**WEST SUSSEX COUNTY COUNCIL  
INFRASTRUCTURE CONSULTATION**

**SUBJECT: AL/9/11**

**Aldingbourne Farm Shop, Nyton Road, Aldingbourne**

**Approval of Conditions 1 & 2 relating to Appeal decision based on AL/128/09**

Drawing 1 / 1 Proposed Screening and Tarmac entrance
All drawings are copyright of BKM
architectural plans and drawings service
and may not be reproduced without prior
permissions

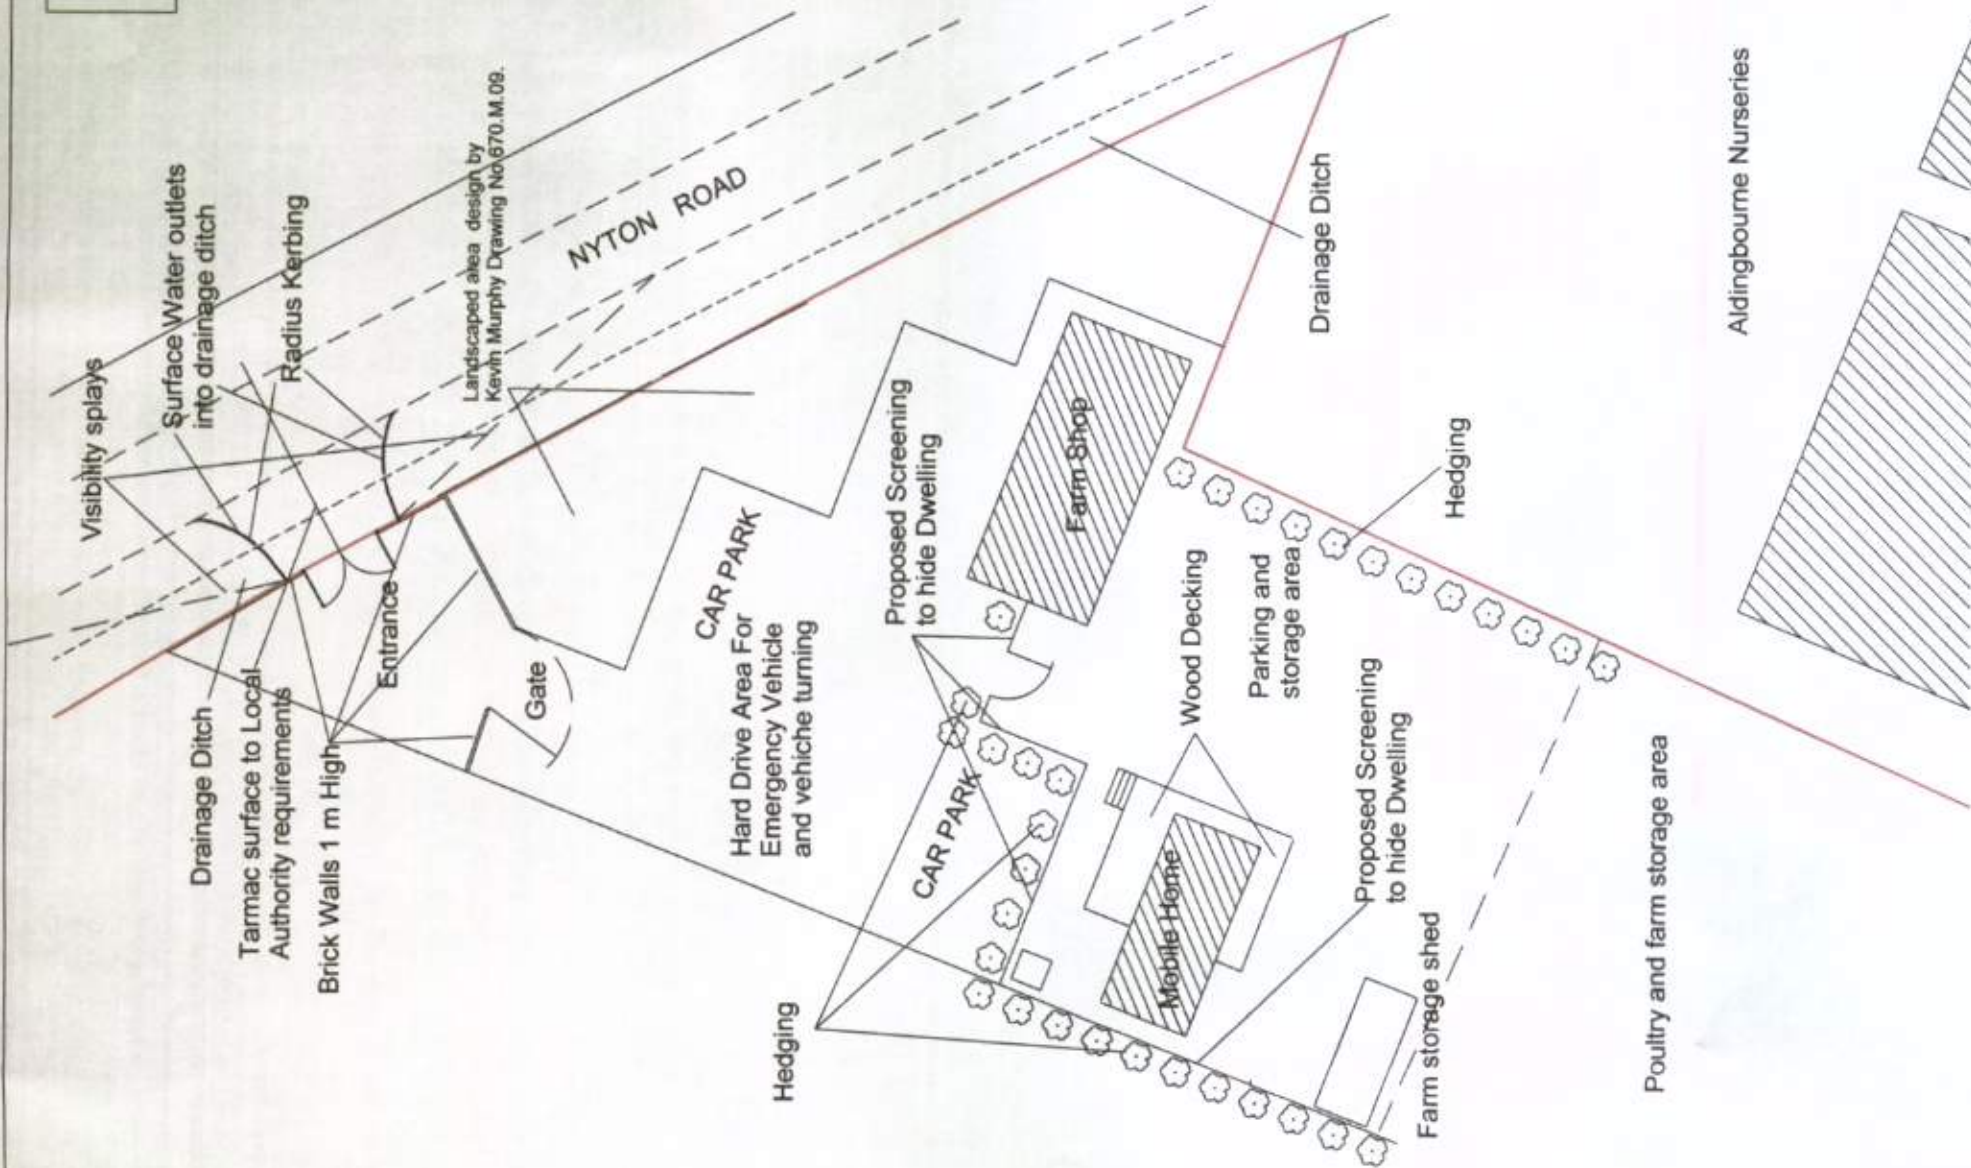
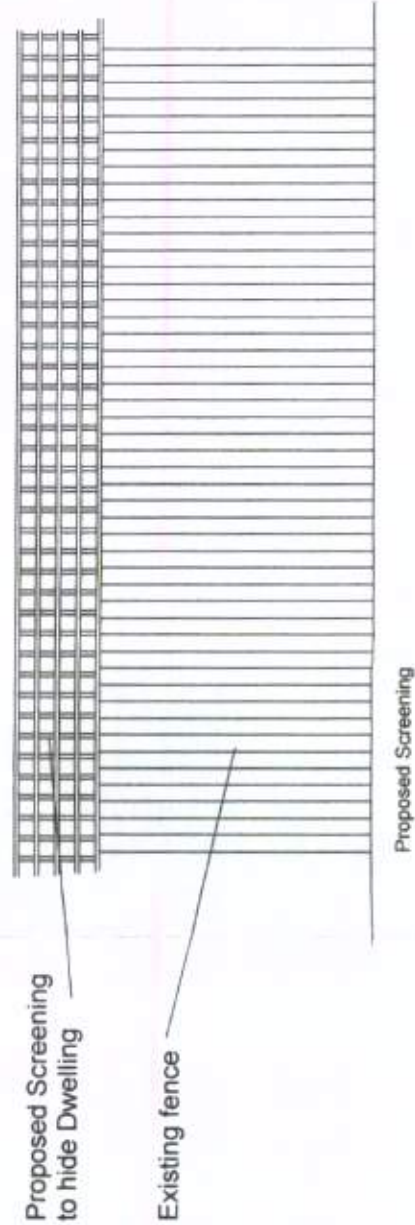
In general terms, the design of the access appears to be acceptable. WSCC, however, would recommend that the condition relating to the access should not be discharged until the access has been constructed and subsequently inspected by the highway authority.
